Our Ref: BR/134/20/NMA

**Section 96A of the Town & Country Planning Act 1990 (as amended)
Town and Country Planning (Development Management Procedure) (England) Order 2015 (as amended) - Article 10**

Non-material amendment following grant of BR/257/17/PL to move entrance door location, move staircase location and additional rear dormer and velux window.

12 Tennyson Road Bognor Regis PO21 2SB

PROPOSED FLOOR PLANS

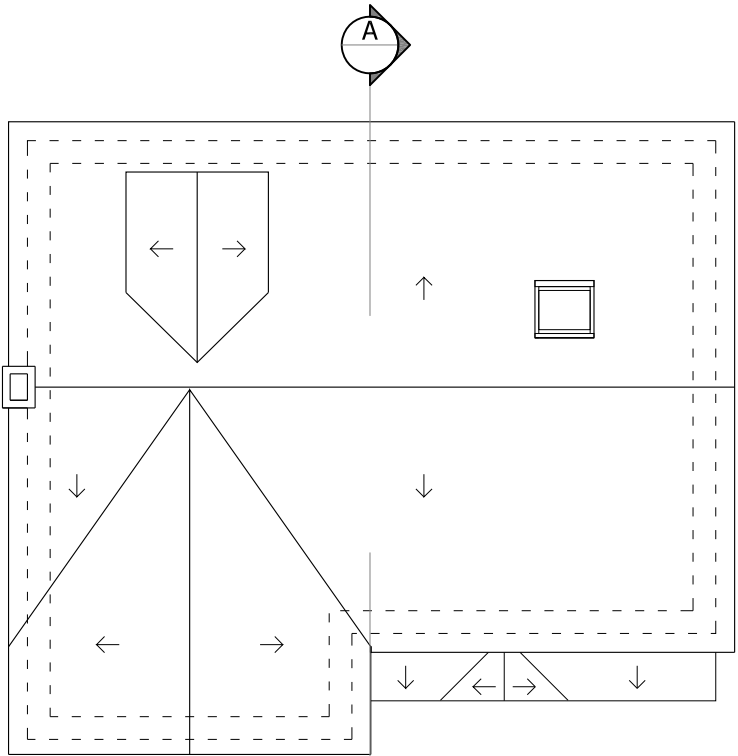
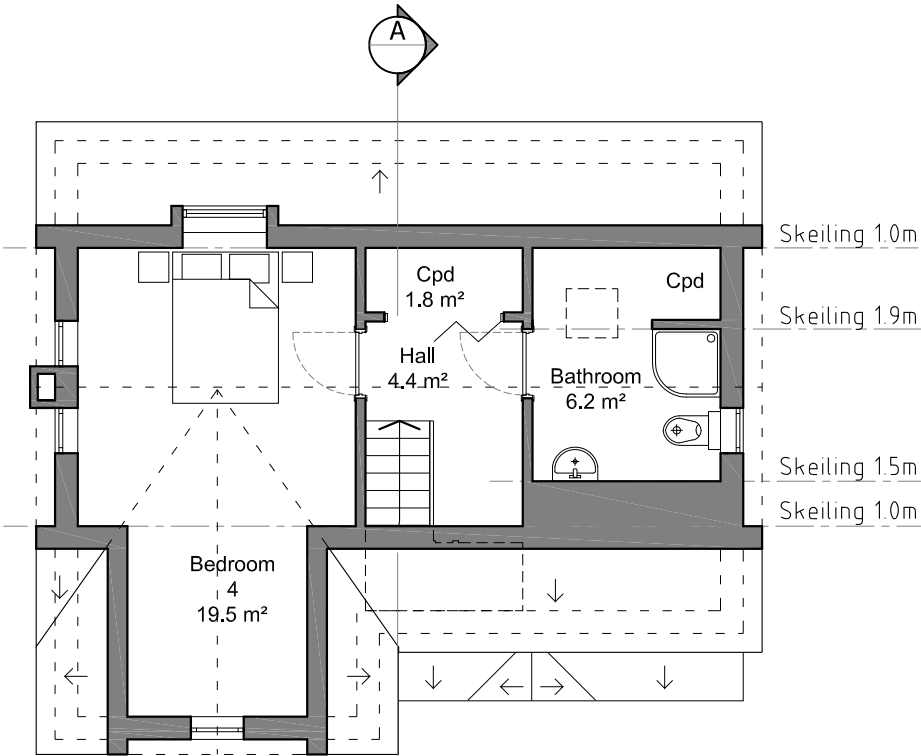
The reasons that this proposal has not been accepted as Non-Material Amendments is because the proposed changes involve a new dormer window (serving to bedroom) to the rear elevation facing to the rear garden and rear elevation of property No 5 Nelson Road with habitable windows within a distance of less than 16 m which would increase the potential violation of the privacy of occupiers at No 5 Nelson Road and therefore introduce amendments which would necessitate consultation with local occupiers. In addition, the permitted development rights has been removed from the proposal property by imposing condition 4 to the planning permission reference BR/257/17/PL, therefore the dormer can't be built as a PD. For the above reasons proposal can't be considered under section 96A of the Town and Country Planning Act 1990.
